## Engineers Comments Regarding Surface Water Drainage

**APPLICATION NO:** Y/88/19/DOC

**Site Address:** North Open Barn Hoe Lane Flansham PO22 8NT

**Description of Works:** Approval of details reserved by condition imposed under ref Y/60/16/PL relating to Condition No 4 - surface water drainage.

P.T. PLANNERS LTD
North Barn Flansham
Drainage Strategy Plan
Dwg 11095-01 03-10-19

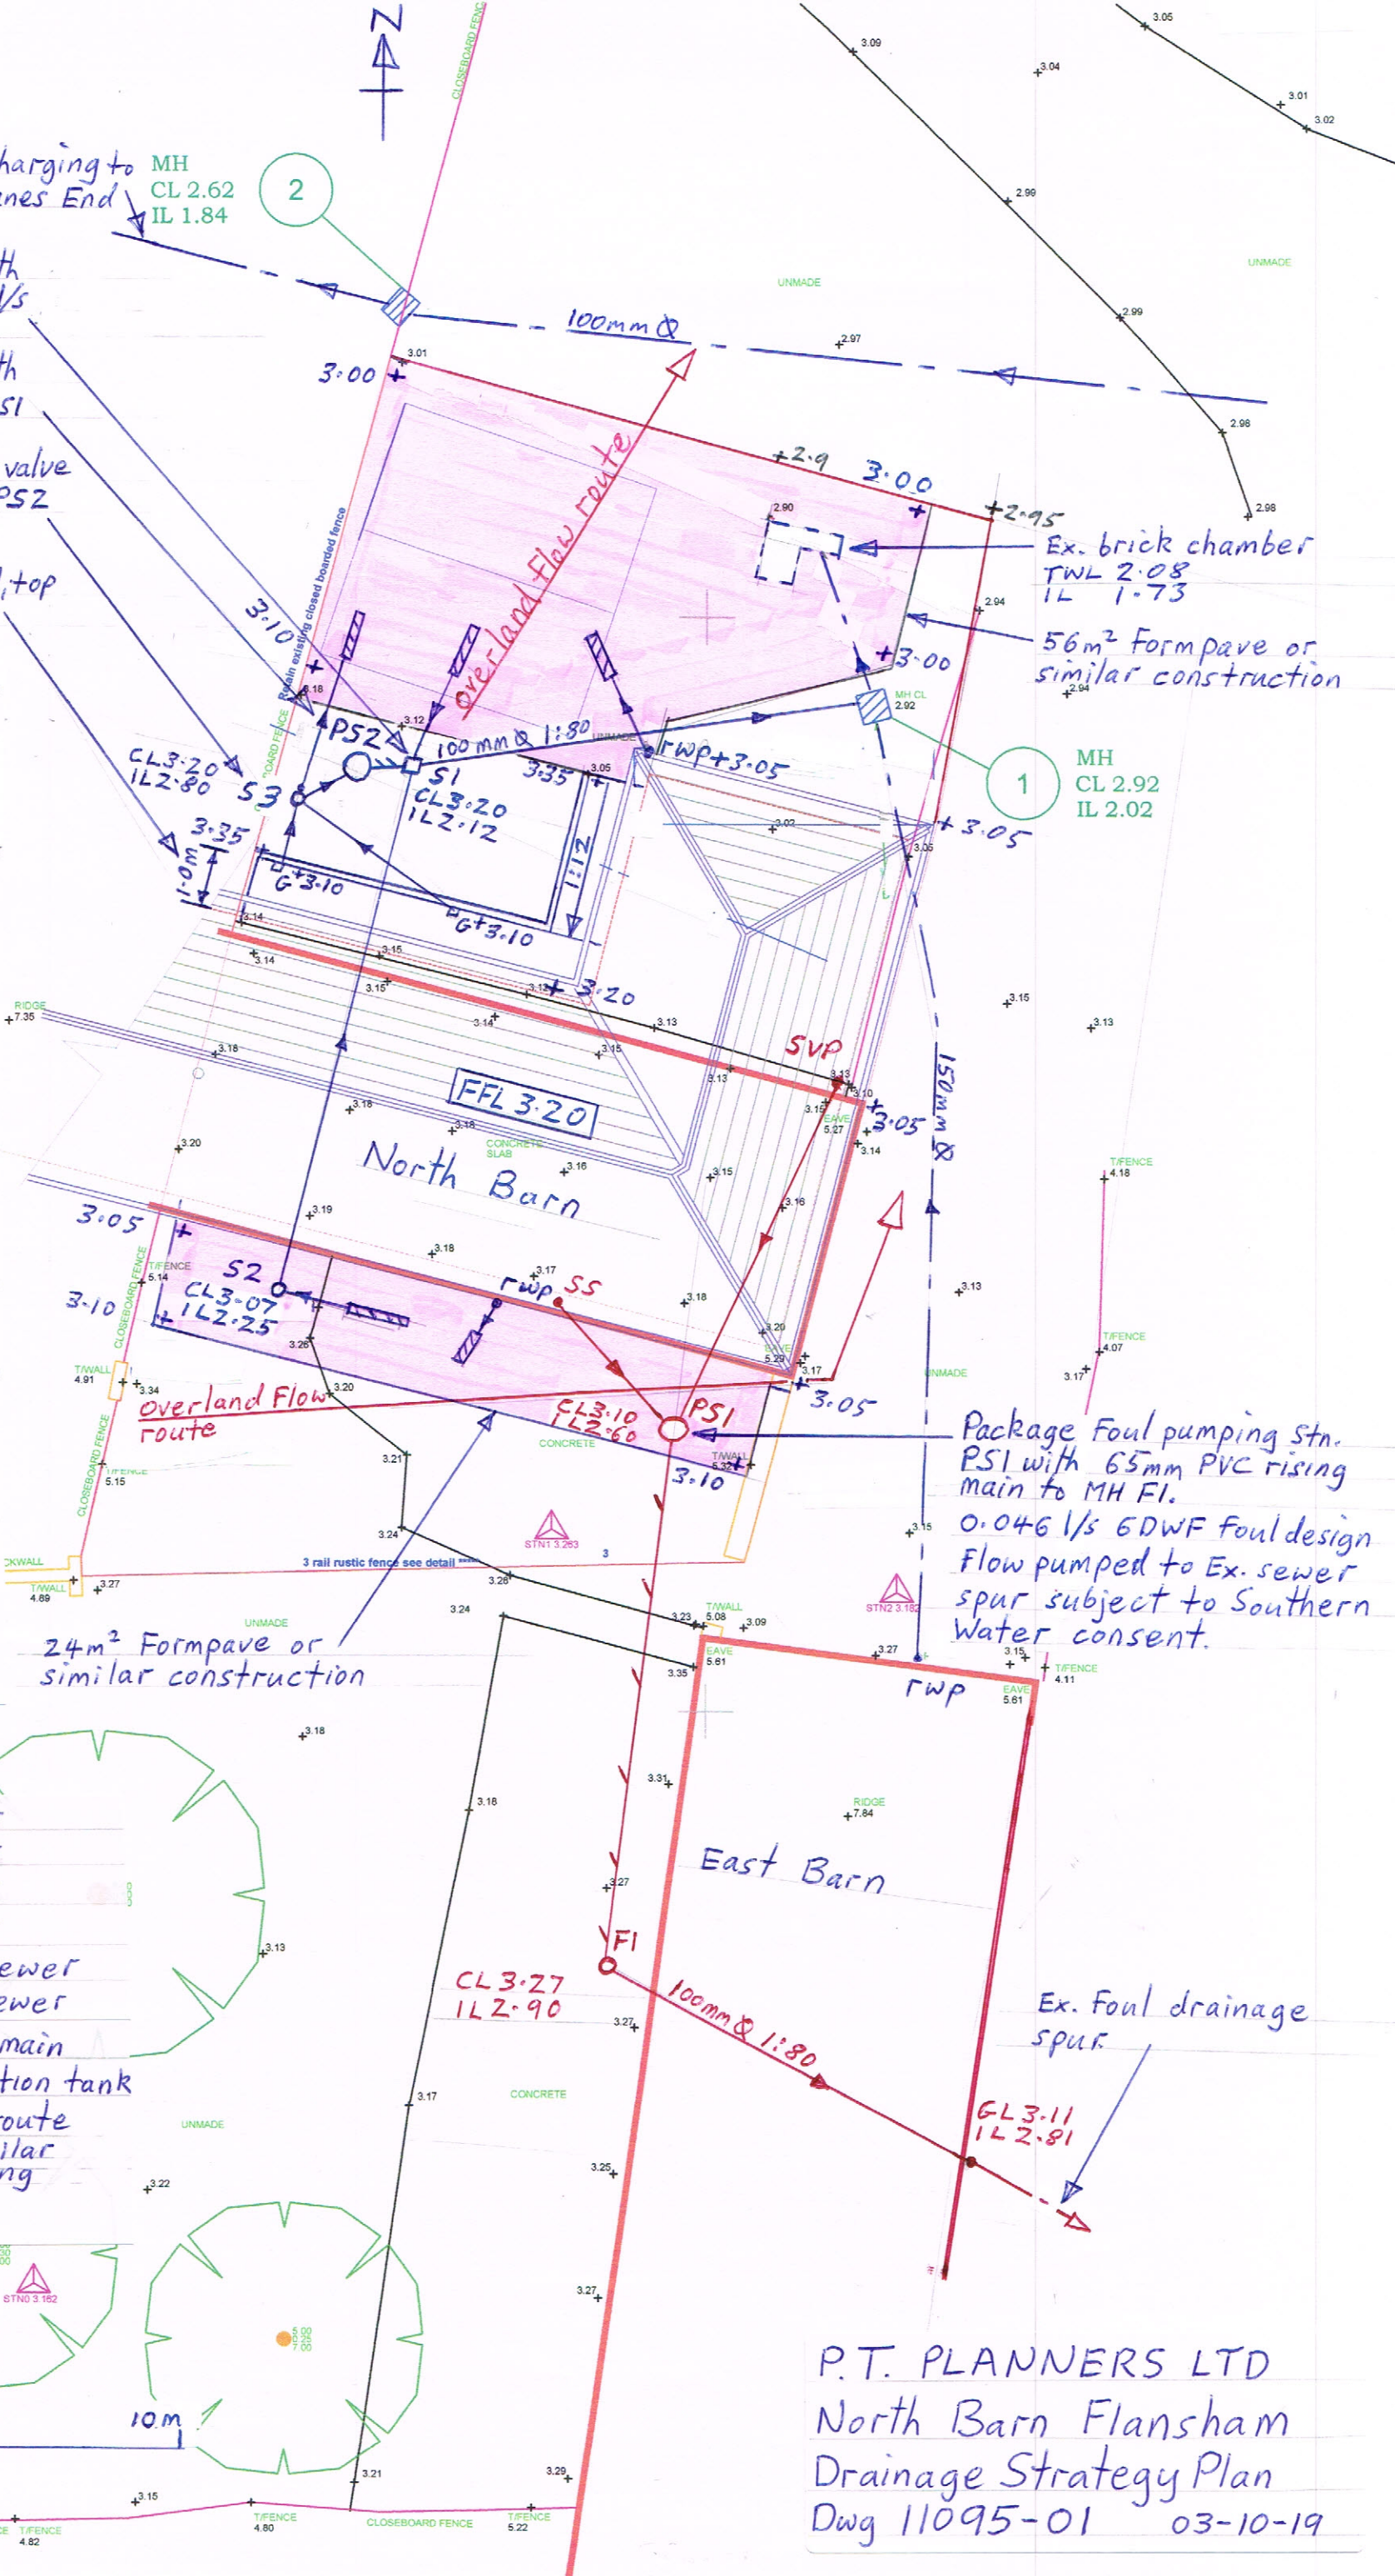
No infiltration testing or groundwater monitoring has been completed. The reason given for this is evidence of clay in the BGS borehole and trial holes. In this case the BGS borehole and trial holes are not an adequate substitution for infiltration testing. Please complete a soakaway test in accordance with BRE 365 to 0.5m depth to assess the viability of shallow soakaways.

The condition clearly states that; *"The design should follow the hierarchy of preference for different types of surface water drainage disposal systems as set out in Approved Document H of the Building Regulations, and the recommendations of the SuDS Manual produced by CIRIA."* Therefore Infiltration is prioritised above attenuation and restricted discharge to a watercourse.
